HUDSON MINOR SUBDIVISION Construction Drawings El Paso County, Colorado

TITLE SHEET

| NO. | REVISION | BY | DATE |
|-----|------------------|-----|--------|
| 1 | COUNTY SUBMITTAL | JPS | 3/8/18 |

C1

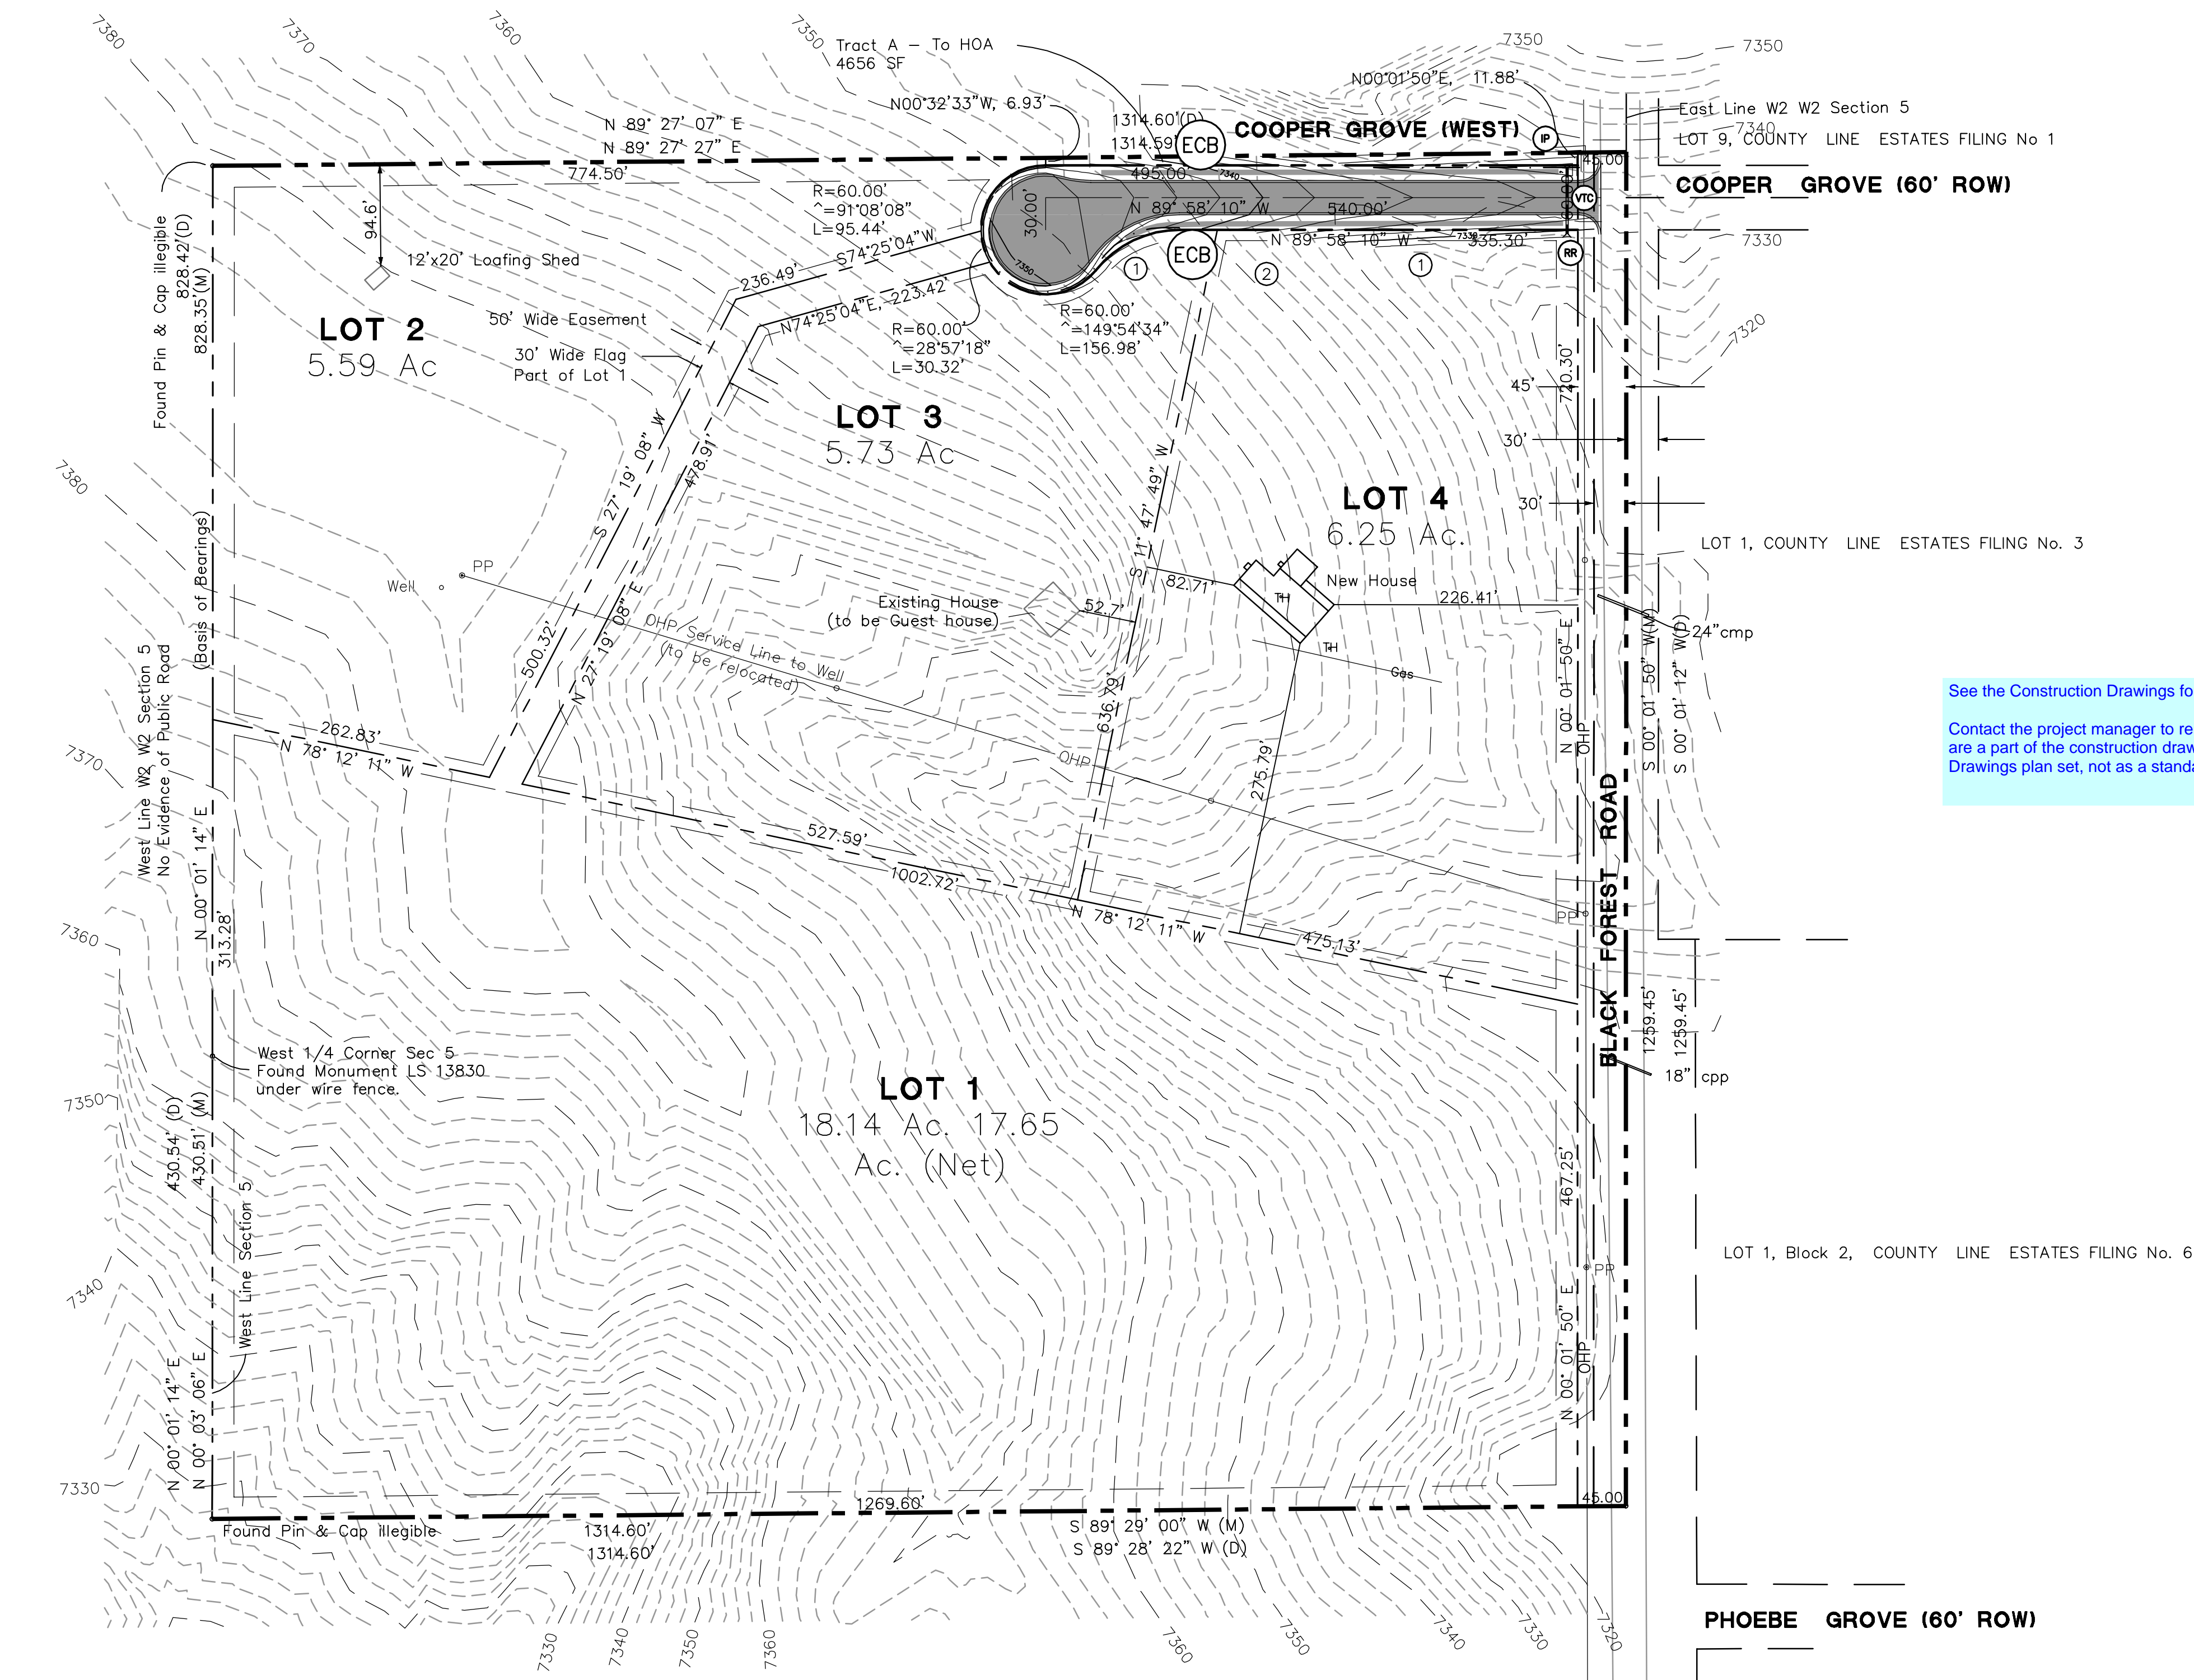
These are not shown on the plan or on the Financial Assurance Estimate

Identify the ECB on the phasing plan

Verify the existing contours along Black Forest Road. No roadside ditches are shown.

| SHEET: | C2 |

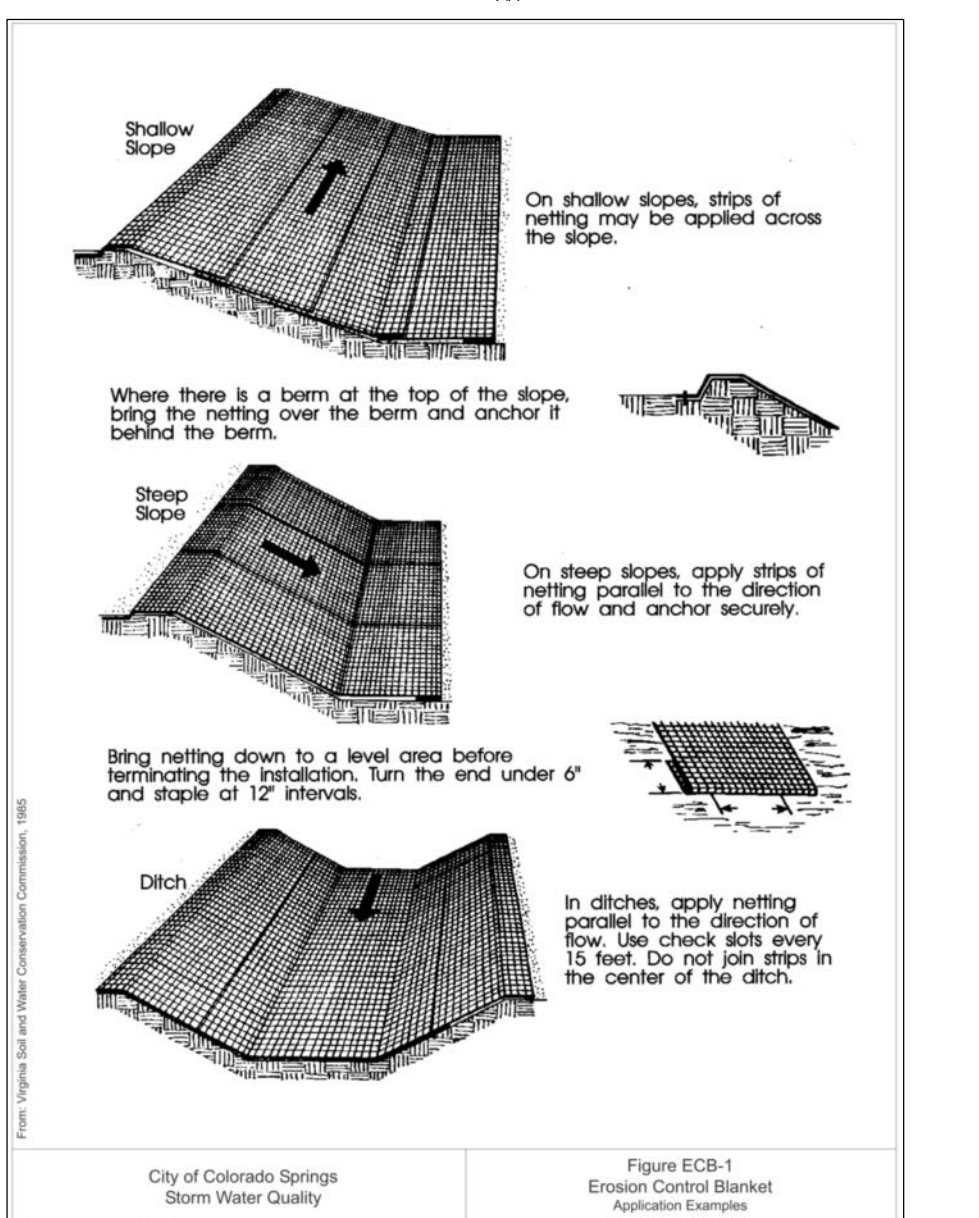
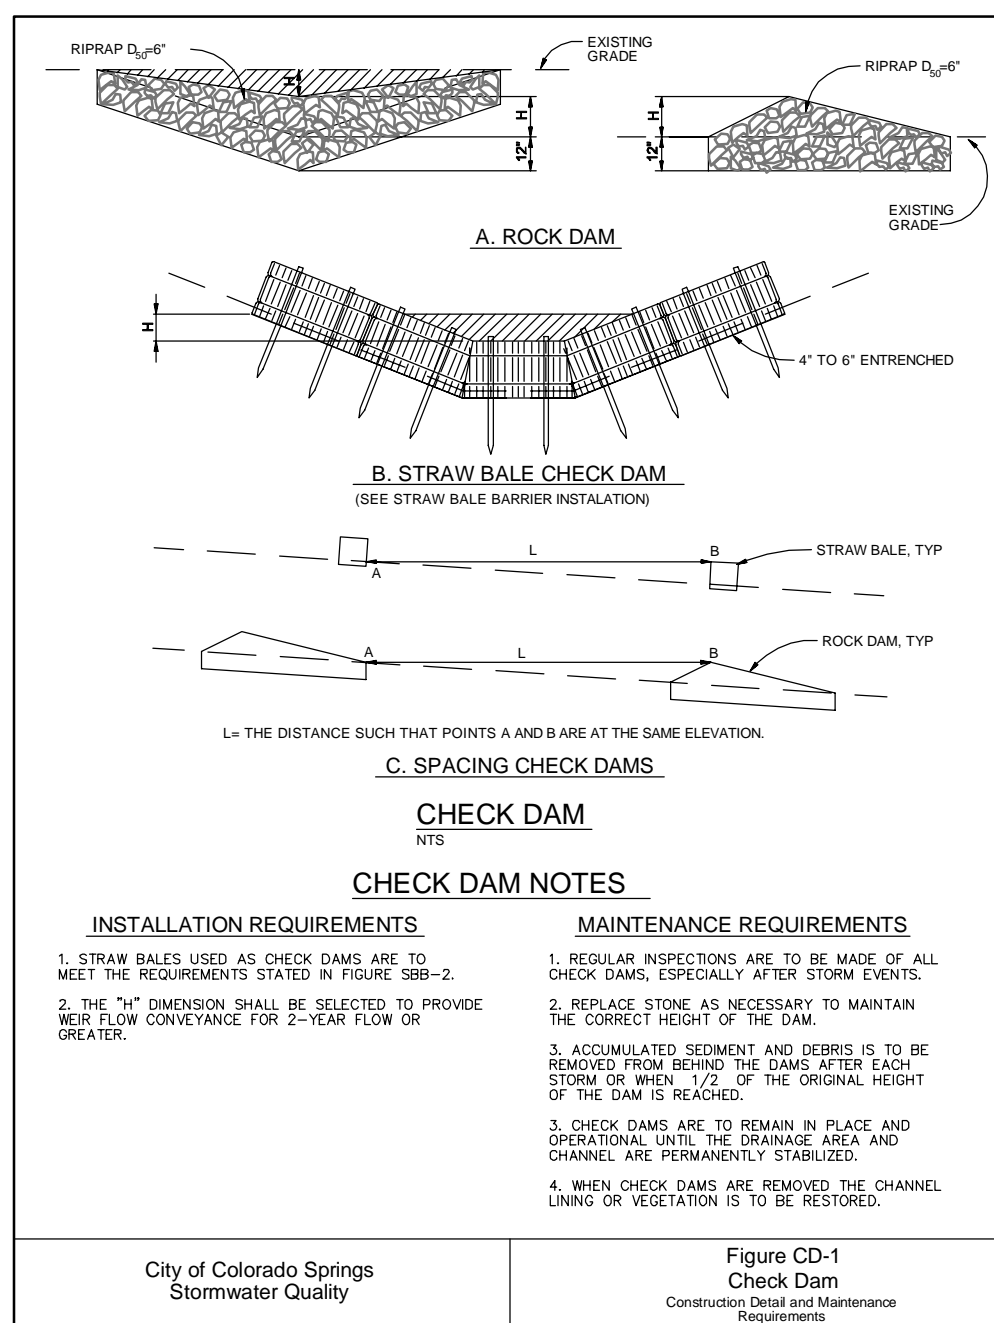
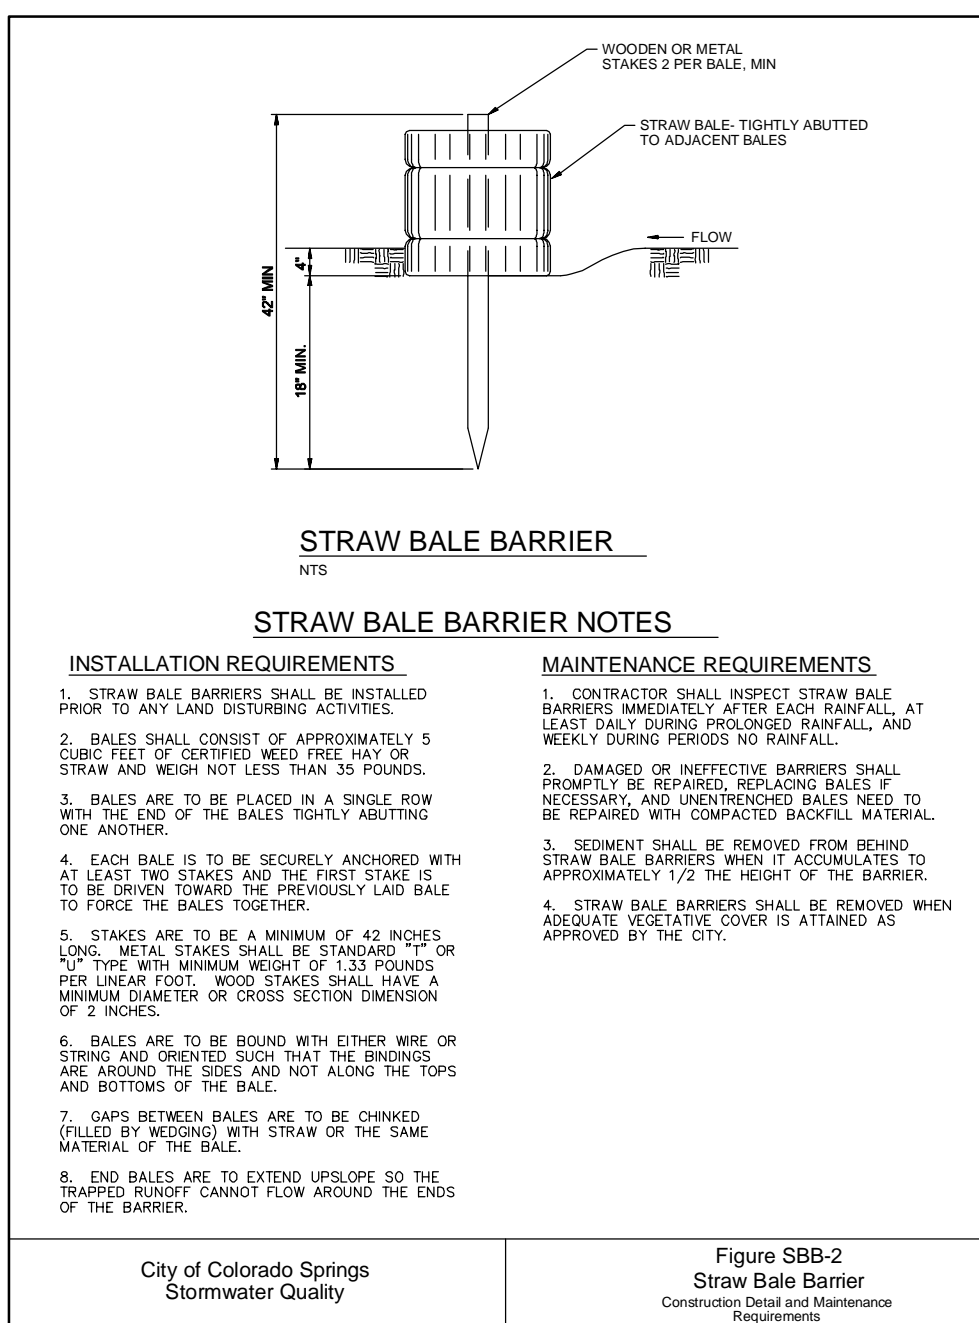
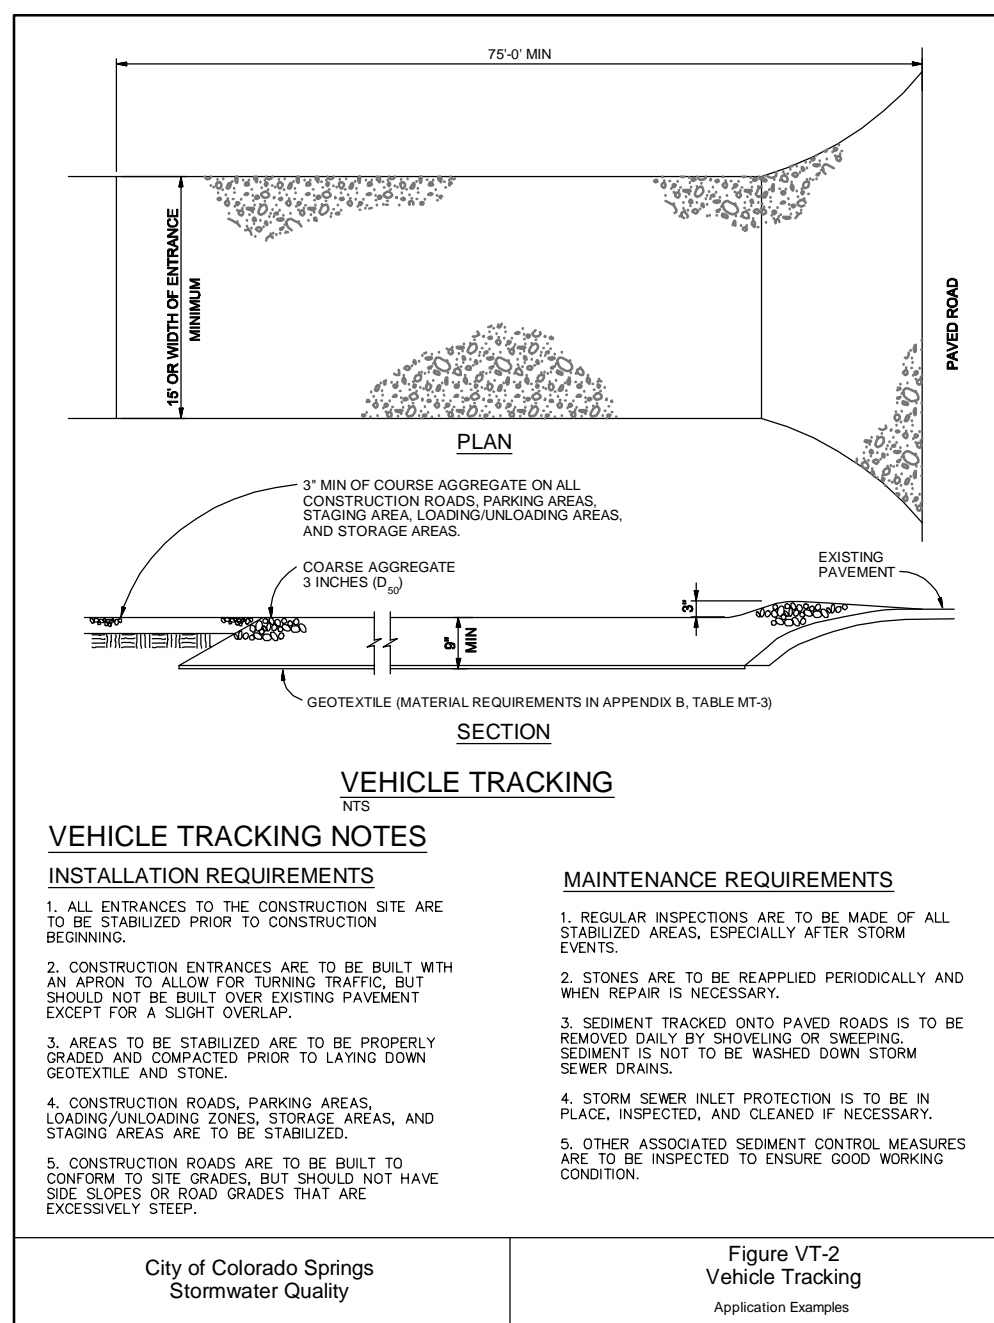
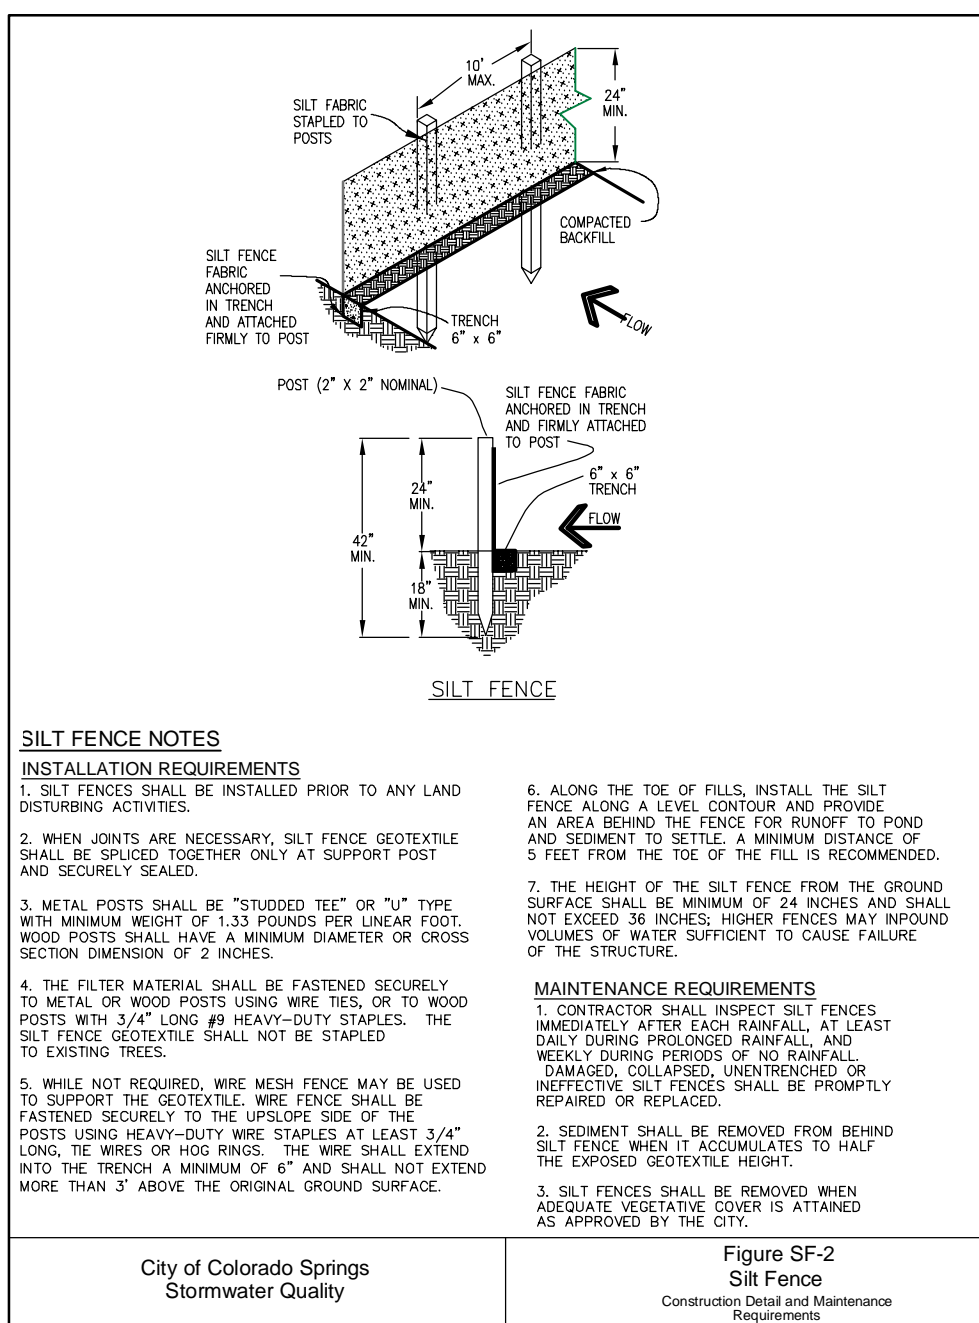
- Construction may not commence until a Construction Permit is obtained from Development Services and a Preconstruction Meeting is held with Development Services Inspectors. Update any any reference to "Development Services" to "Planning and Community Development"

- A water source shall be available on site during earthwork operations and utilized as required to minimize dust from earthwork equipment and wind.
- The soils report for this site shall be considered a part of these plans. Update to reference the specific report.
